CITY OF ALBUQUERQUE

**RE: Chick-fil-A at Gibson
1600 Gibson Blvd SE
Requested for 30 Day Temporary C. O. - Accepted
Engineers Stamp Date 7/29/15 (M15D012C)**

Based on the certification provided in your submittal received 12/2/2015, the above referenced is approved for a 30-day Temporary Release of Occupancy by Hydrology. However, before a permanent CO can be accepted the following comments must be addressed.

SHEET TITLE
GRADING PLAN

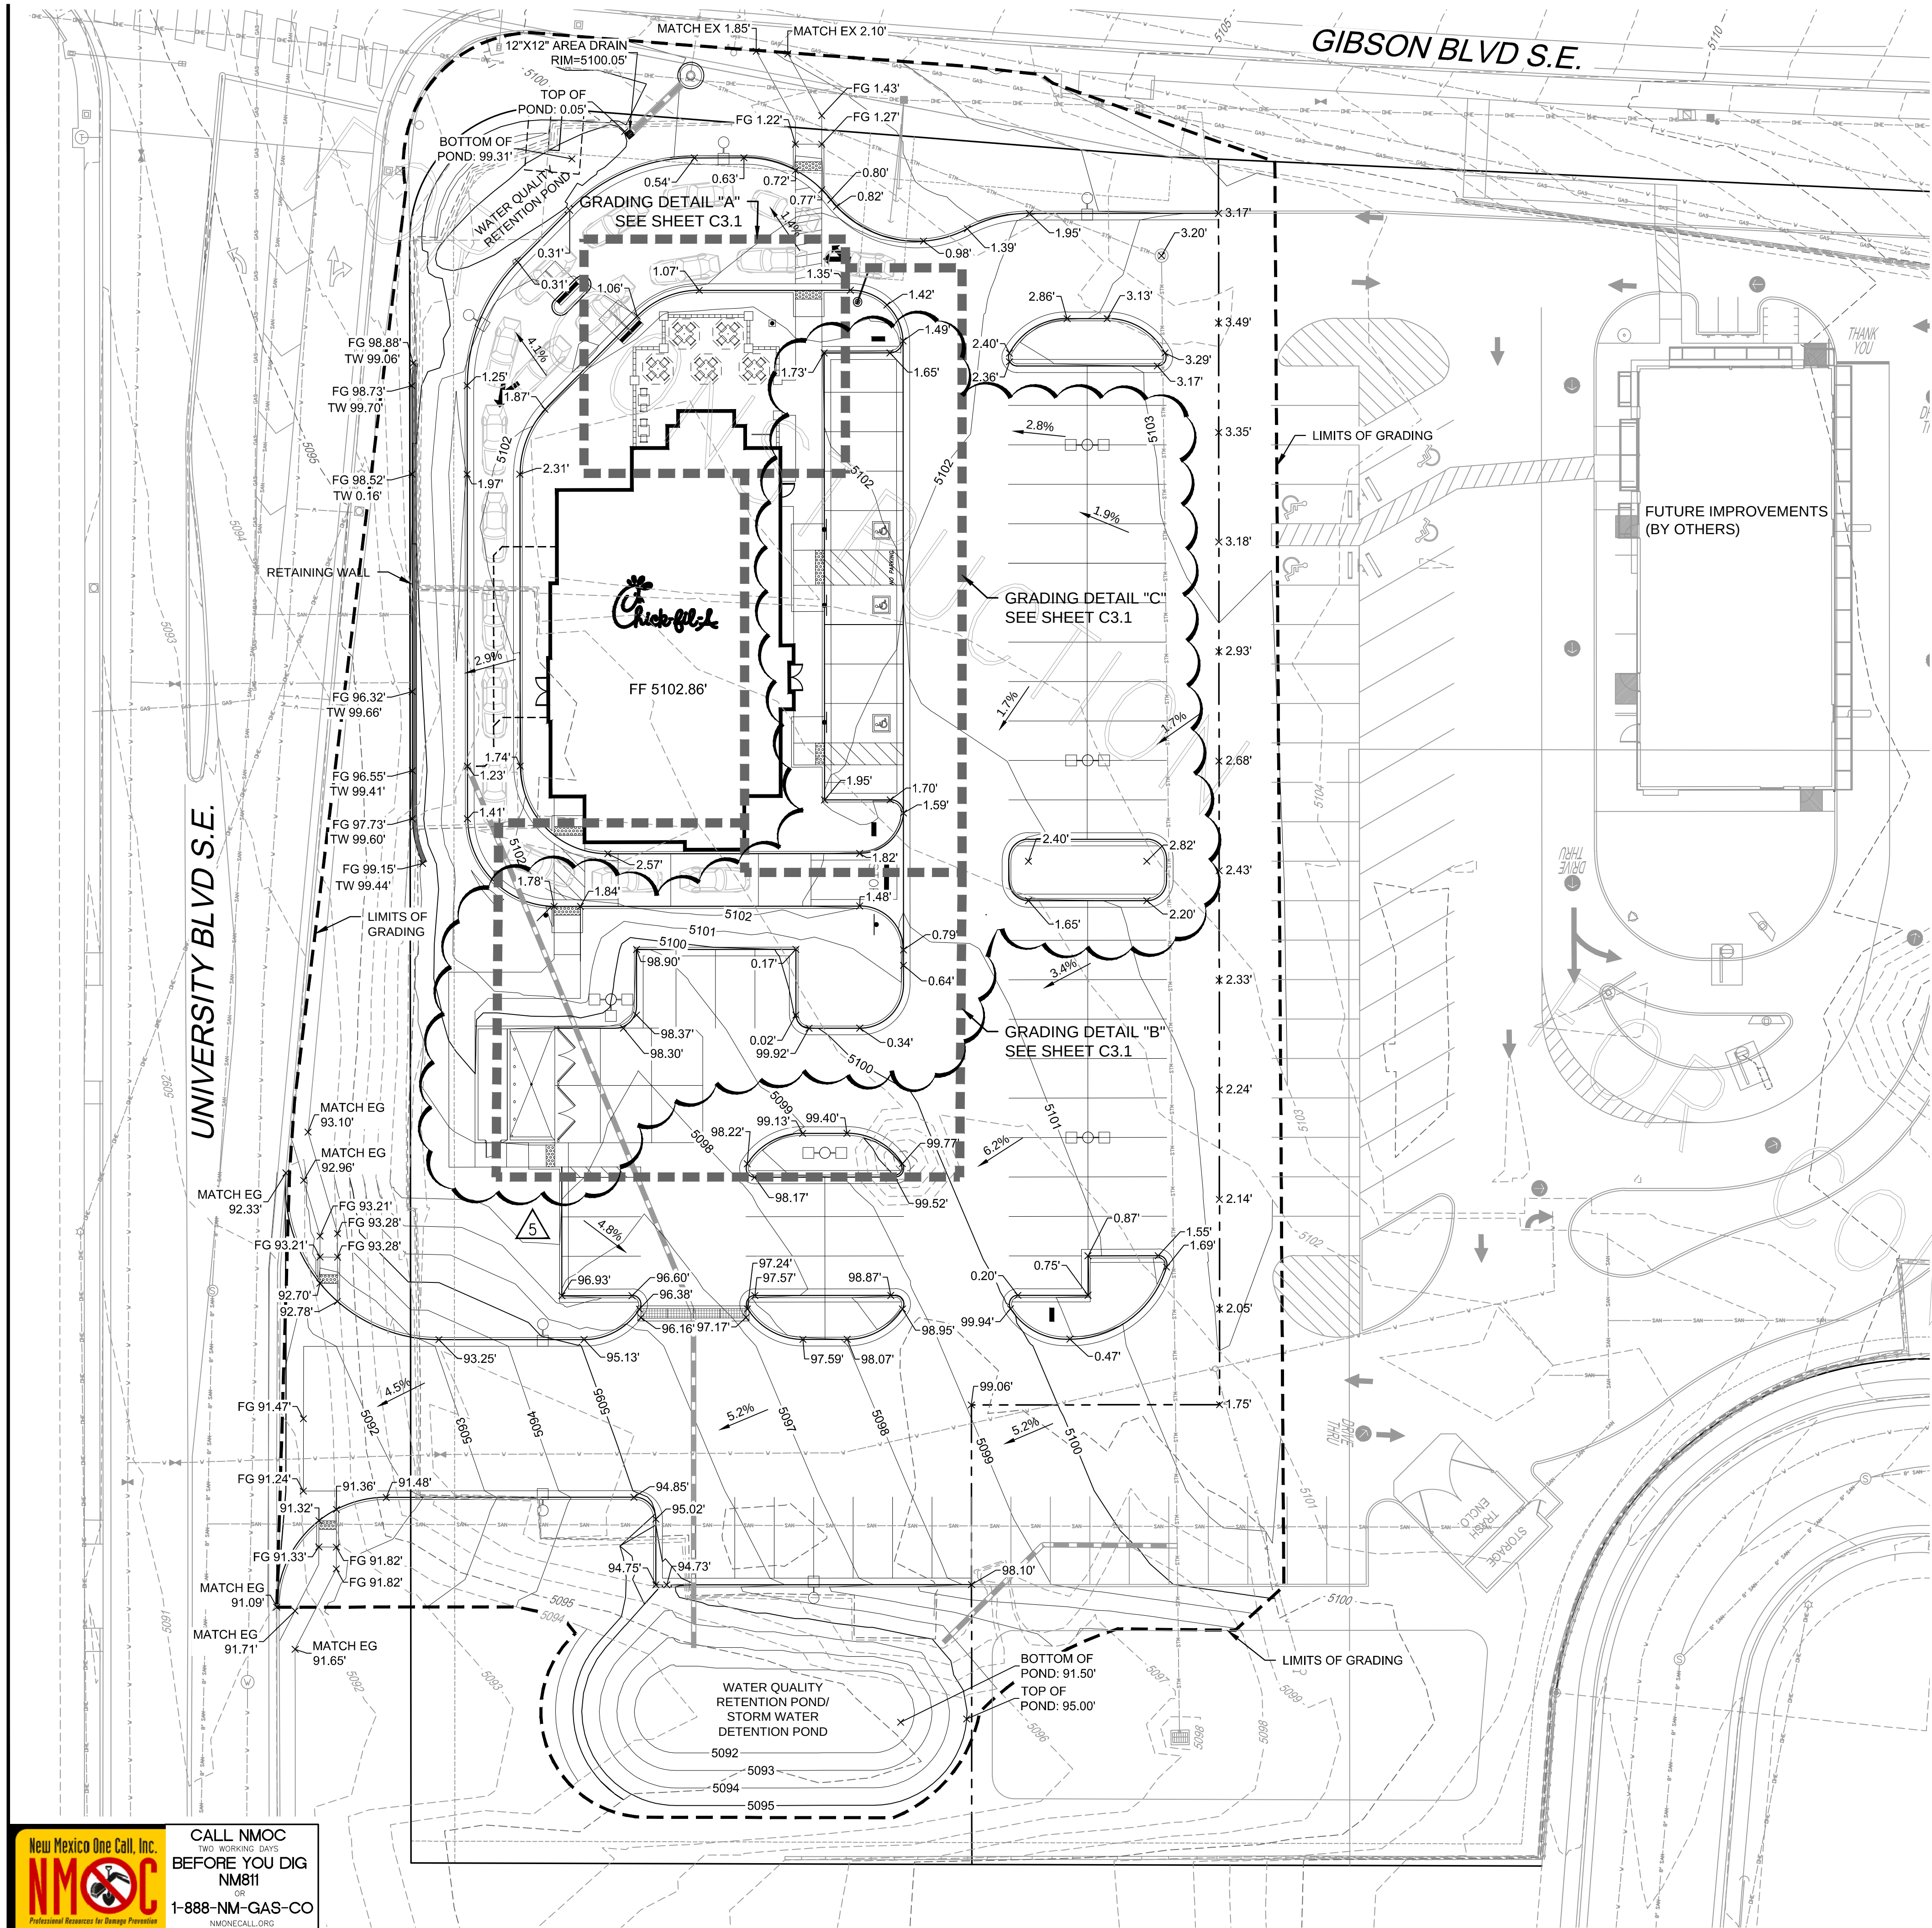
- The pond on the south side must be completed.
 - The drain in the dumpster must be cut at grade and a drain placed over it.
 - The 12" x 12" area drain on the NW corner must be cut and grate placed over it.
- An inspection by our office will need to take place after plan is provided.
